From: Chantelle Bashford [REDACTED]
Sent: 07 November 2025 14:40
To: Planning.Responses <Planning.Responses@arun.gov.uk>
Subject: RE: Planning Consultation on: LU/195/25/PL

Application No: LU/195/25/PL

Site Address: 1 & 2 Norfolk House Beach Road Littlehampton BN17 5HZ

Description of Works: Change of use from offices to 2 No. 1 bedroom flats. This application is in CIL zone 4 (zero rated).

Ground Floor

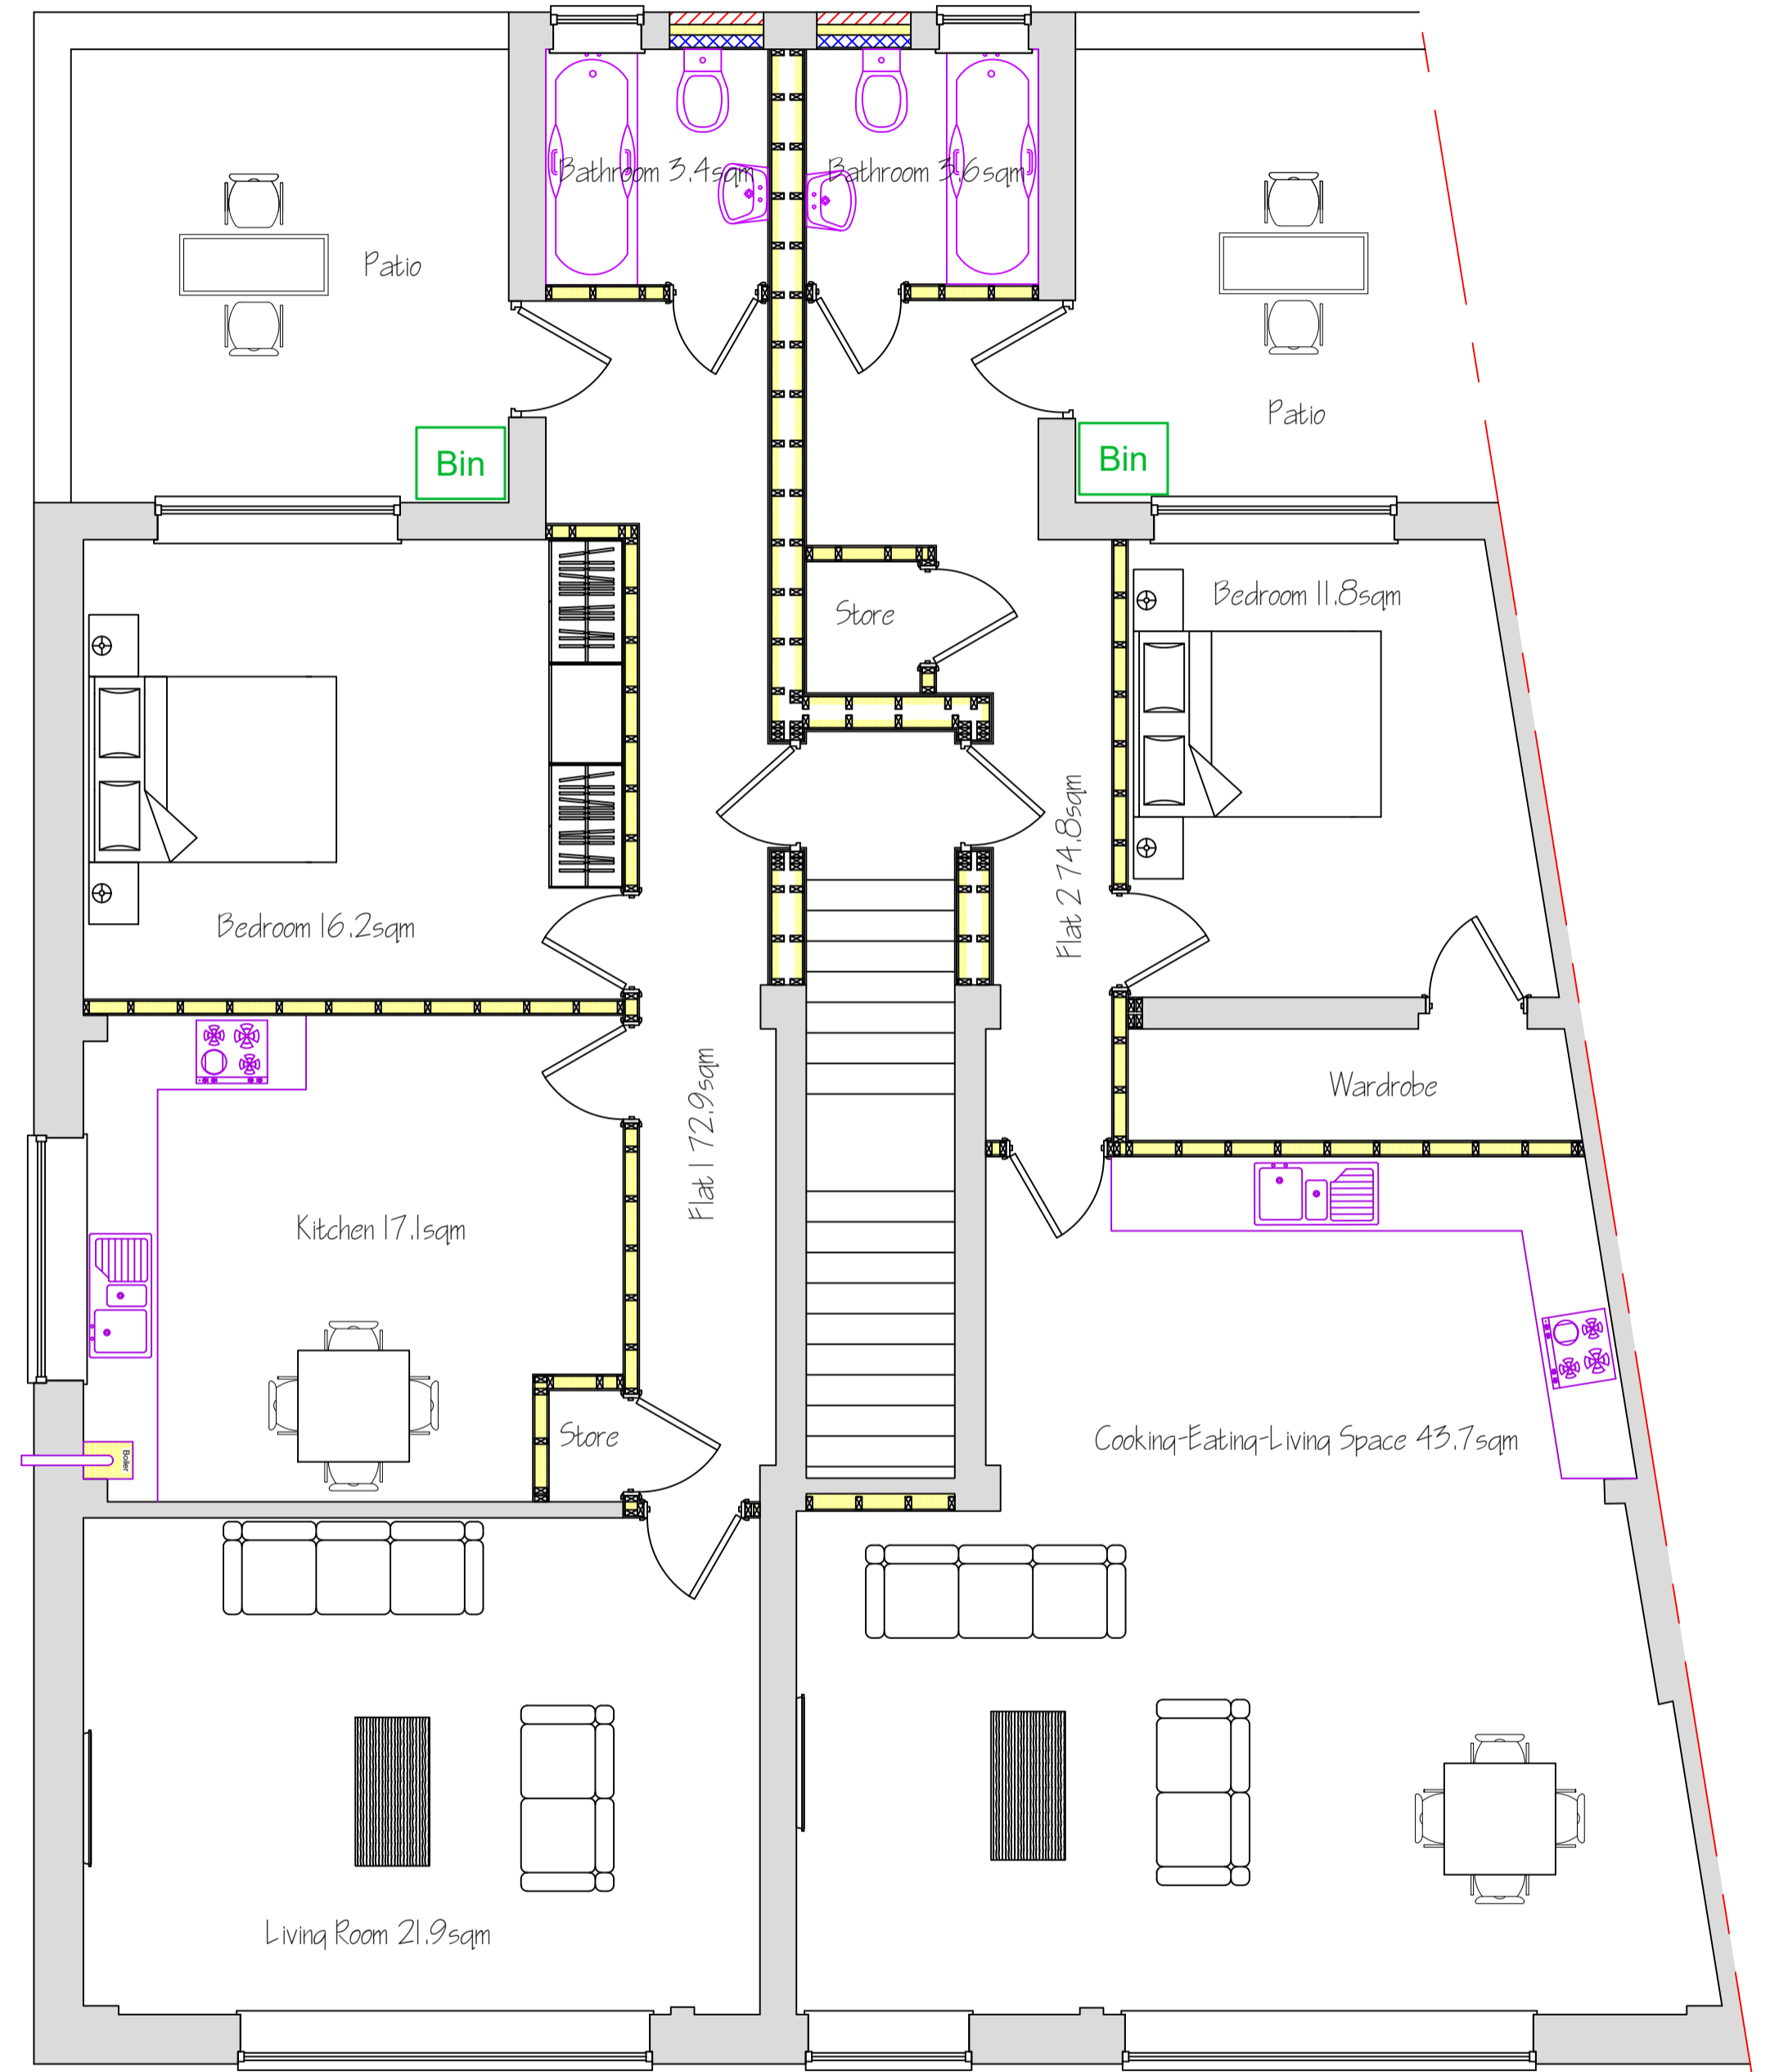
- Each first floor patio area must provide a guarding height of 1100mm minimum, extending up from the patio floor, with openings that would not allow a sphere with a 100mm diameter to pass through. The guarding should not be constructed so as to facilitate climbing by children
